**KIRKLEES METROPOLITAN COUNCIL
INVESTMENT & REGENERATION SERVICE**

DELEGATED DECISION TO DETERMINE PLANNING APPLICATIONS

Reference No:	2025/62/91419/E
Site Address:	former Commercial Hotel, 125, Wellington Street, Batley, WF17 5TH
Description:	Erection of commercial unit (vehicle software diagnostics centre) with 3 flats above
Recommending Officer:	Nina Sayers

DECISION - REFUSE

Rev:	Revision Note:	Date:
Client:	MR A. AZEEM	
Project:	125 WELLINGTON STREET, BATLEY, WF17 5TH.	
Title:	PROPOSED BLOCK PLAN	
Scale:	Date:	Drawing No:
1:100@A1	APRIL 25	2543-1
Revision:	-

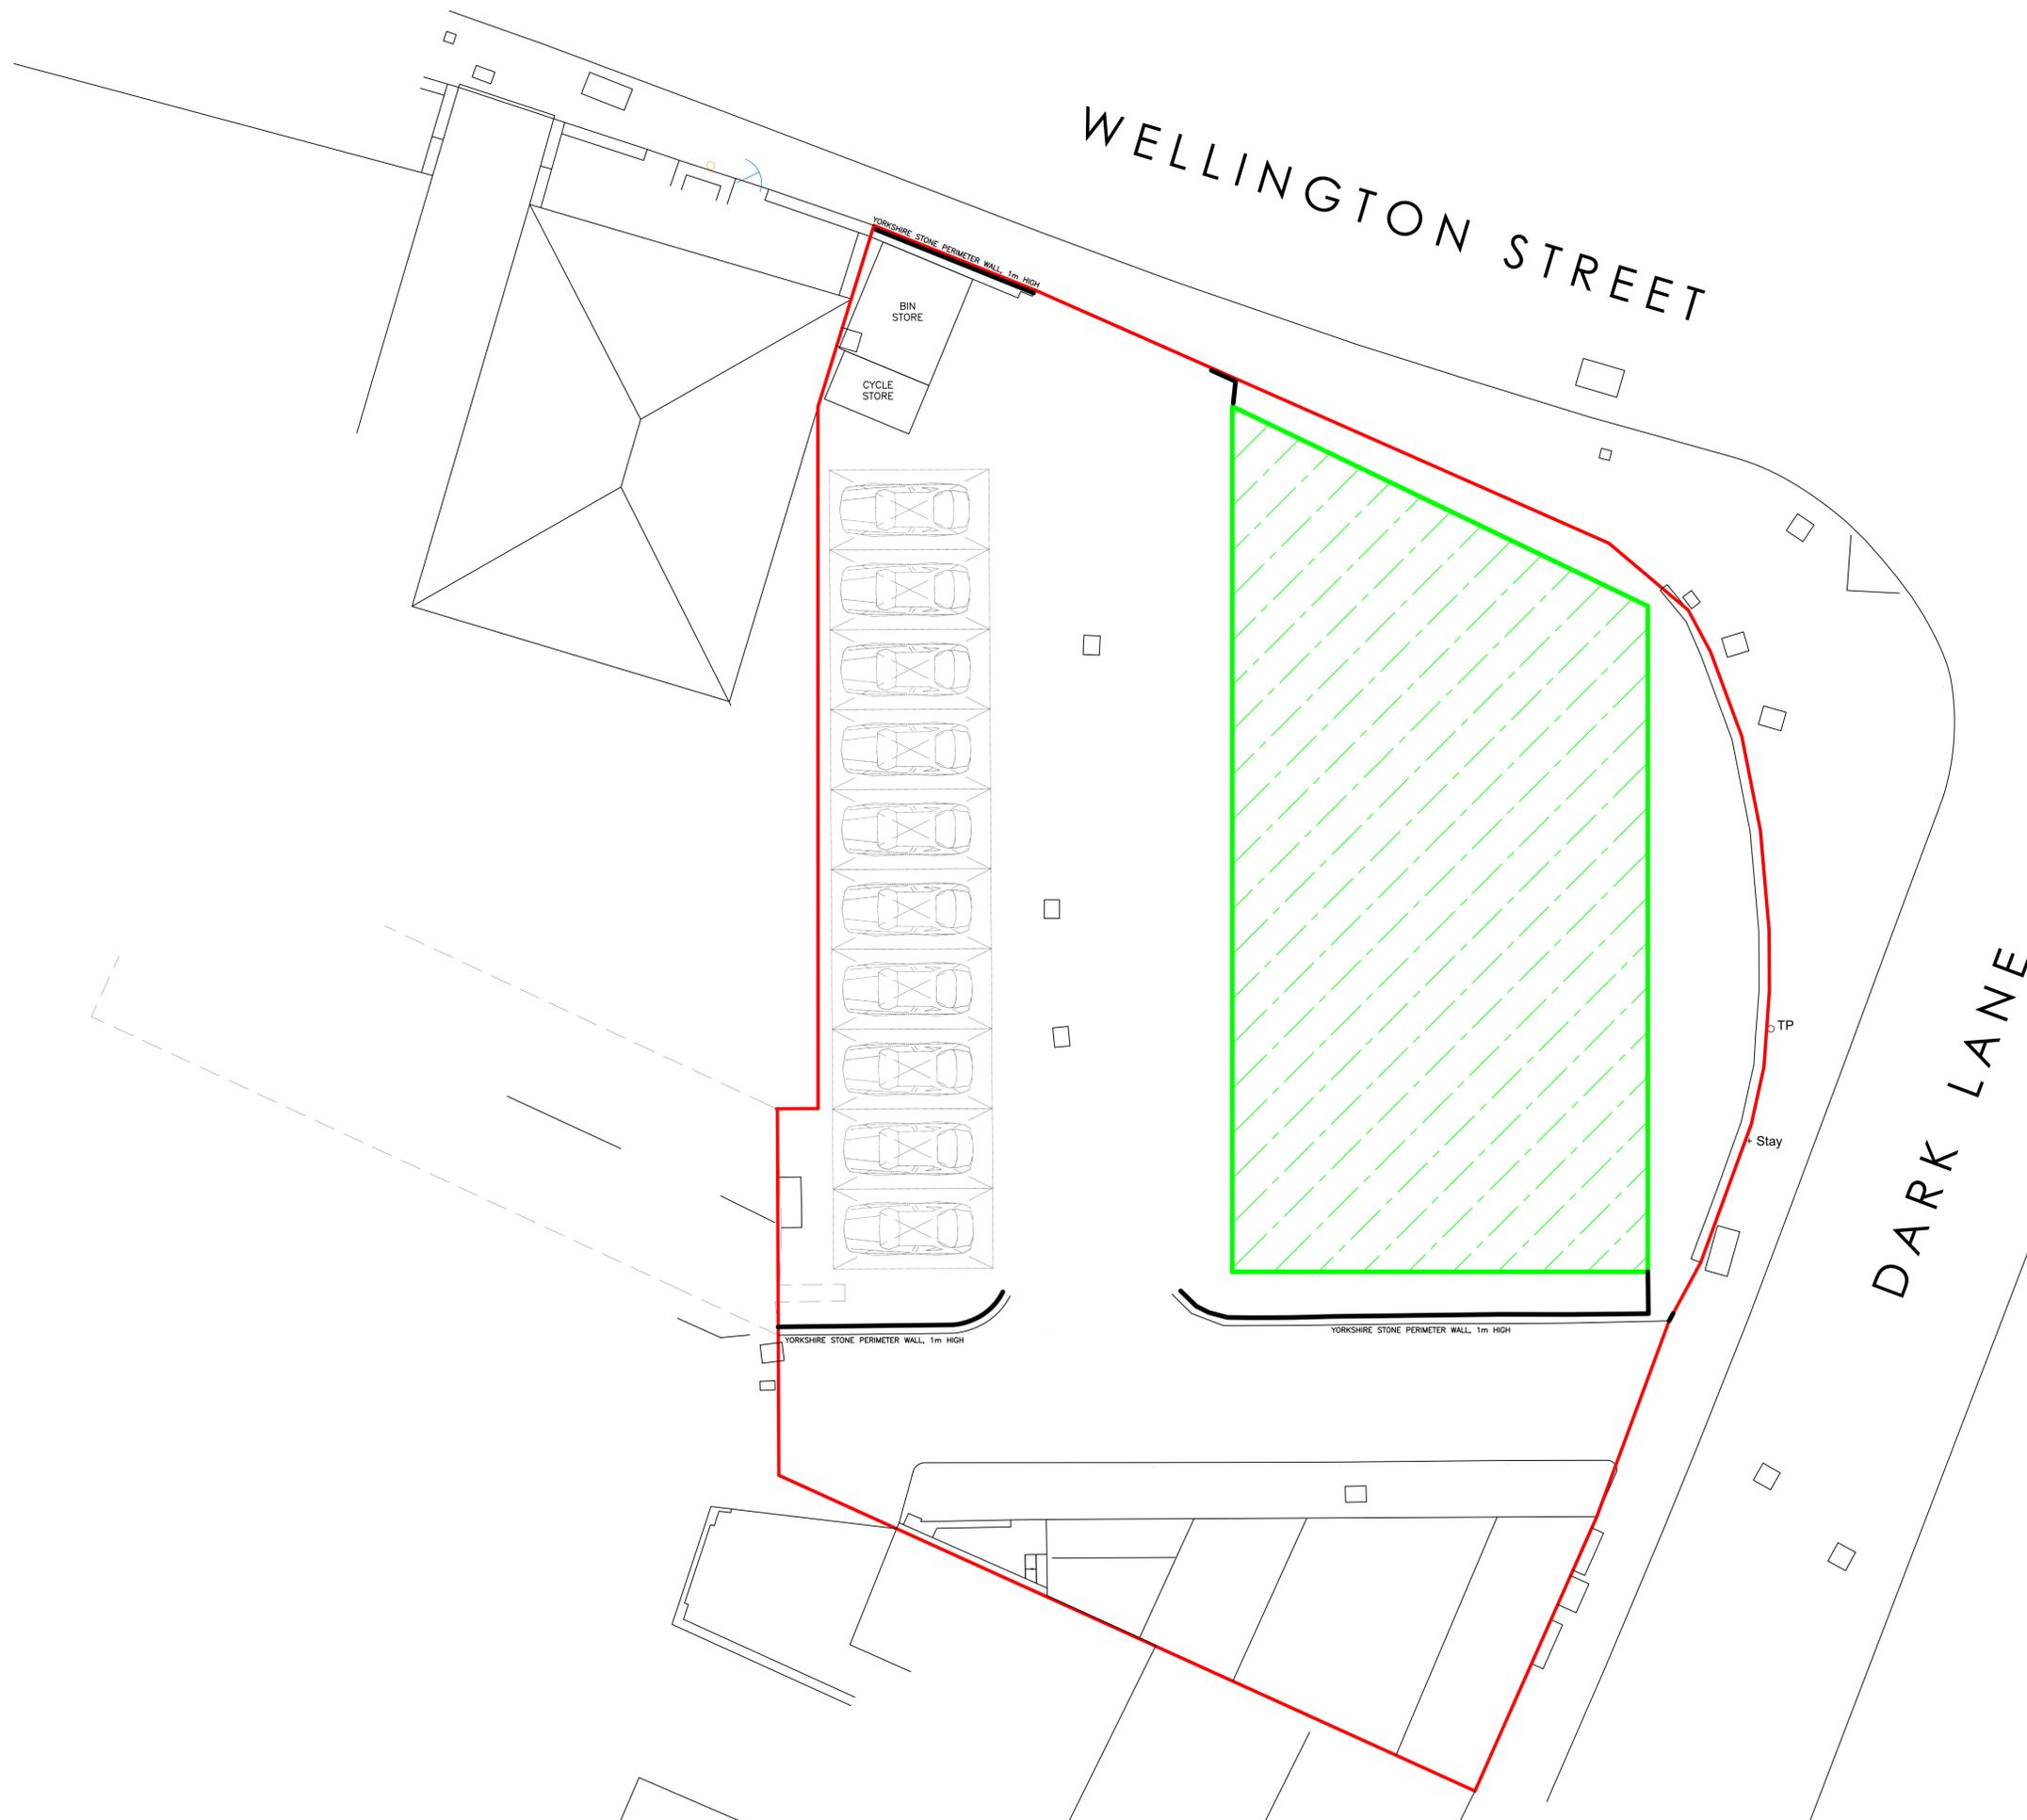
The proposals show a new commercial unit with residential use above with 10 off-street parking spaces. Access is via Wellington Street and Dark Lane and cycle and bin storage are provided adjacent to the highway.

KC Highways Development Management (HDM) were consulted on the proposal and object on the basis that the proposal is for a garage with potentially 6 bays with 3 two bedroomed flats above. There is not enough parking and it's on a junction (Wellington Street and Dark Lane). They would normally require 2 spaces per bay plus staff parking for the garage and further parking for the residential units.

It is noted that application 2024/92495 proposed the same number of parking spaces for a 6 bay commercial unit however no residential use was proposed under the previous application. It is also noted that the parking area was significantly larger under the 2024 application. It is therefore considered that whilst the previous application's parking provision was considered acceptable, on balance, the further intensification of use of the site could not be supported by officers as there would not be sufficient parking proposed.

As such, the proposed development is considered to not provide sufficient off-street parking provision and therefore would cause harm to the efficiency and safety of the highway. The proposed development fails to comply with LP21, LP22 and LP24 of the Kirklees Local Plan and paragraph 116 of the NPPF as well as the aims of the Highways Design Guide SPD.

Rev:	Revision Note:	Date:
Client:	MR A. AZEEM	
Project:	125 WELLINGTON STREET, BATLEY, WF17 5TH.	
Title:	PROPOSED PLANS & ELEVATIONS	
Scale:	Date:	Drawing No:
1:100@A1	APRIL 25	2543-2
		Revision:
		-

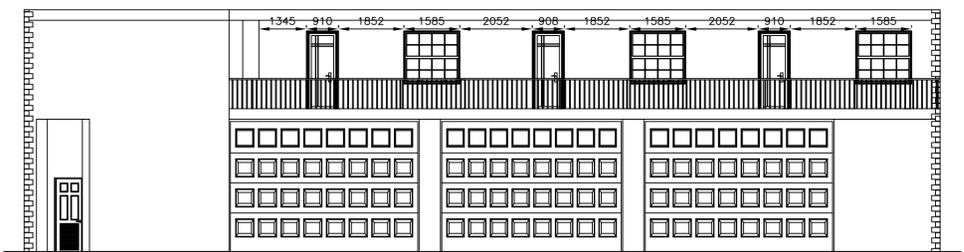
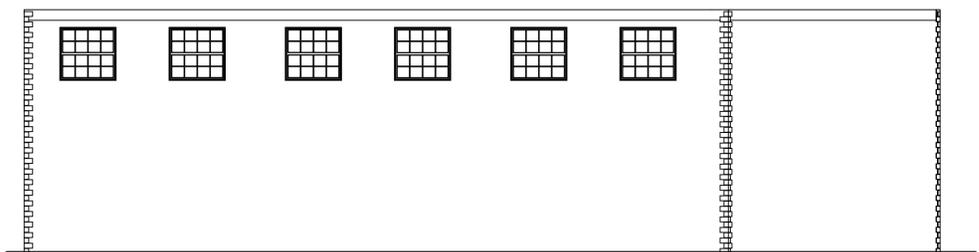
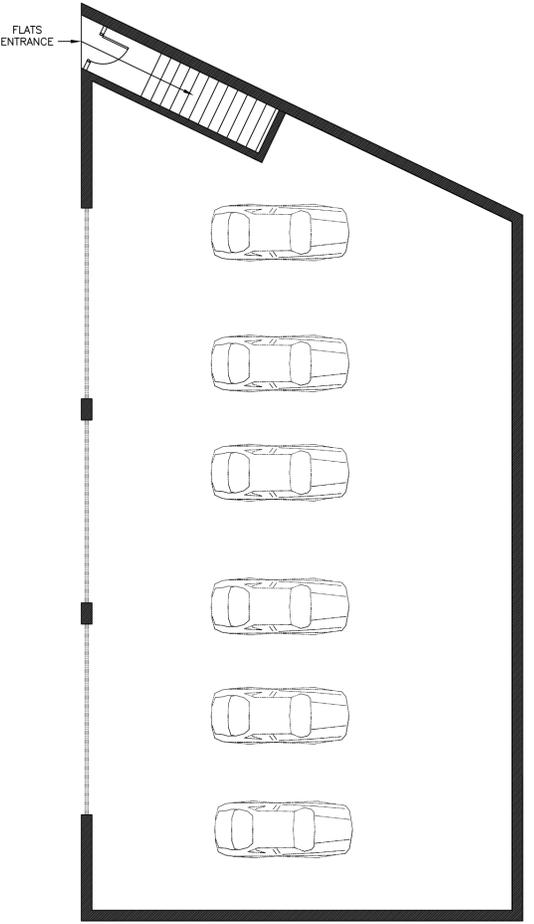
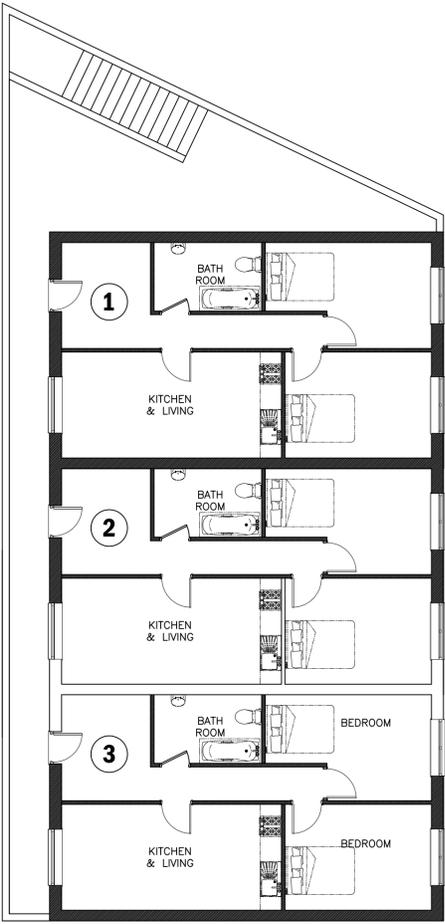
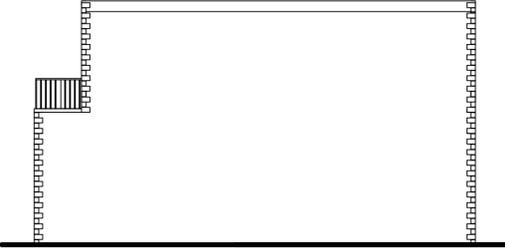
The building proposed covers a large footprint and would be located in a prominent location on the corner of the Wellington Street and Dark Lane. The existing development surrounding the site is characterised by two-storey pitched and hipped roofed buildings. The scheme proposes a flat roofed building with terraced access, which would not be in keeping with the existing development. The combination of the scale, design and location is considered to be an incongruous addition which would not sympathetically integrate into the street scene.

The applicant proposes Yorkshire Stone and composite cladding. There is no composite cladding on the buildings surrounding the site which are predominantly finished in stone and therefore the use of composite cladding would be considered incongruous within the street scene. Should this application be approved, officers would be recommending the walls are finished in Yorkshire Stone, to be in keeping with the existing development surrounding the site.

Having taken the above into account, the scale, massing and location of the proposed development is considered to cause significant harm to the visual

The proposed building would be located 7.4m from the front elevation of no.6 and 9 Dark Lane. Due to the triangular shape of this building, the primary openings are in the northern elevation which fronts the site. Officers have concerns that the proposed building would cause overshadowing and overbearing harm on the occupants of no.9. As the proposed building would be directly north of no.6 and 9, no significant overshadowing harm is considered to occur. The proposed side elevation however would have an overbearing impact and would not meet the recommended separation distance. It is noted that the building is in a similar location to that approved under application 2024/92495 however, the approved building had a pitched

The scheme proposes three, two-bedroom flats at first floor level. The units would all have an internal floor area of 63.9m². The proposed dwellings would fail to meet the minimum recommendations as set out within the NDSS for a two-bedroom, two-person, single storey dwelling (70m²). The proposed dwellings also have no amenity space. It is considered the proposed windows would have sufficient outlook and natural light for the amenity of future occupants. Notwithstanding this, it is considered that the proposed unit would fail to provide adequate floor space for future occupants, thus failing to comply with LP24(b) of the Kirklees Local Plan and paragraph 135(f) of the NPPF.
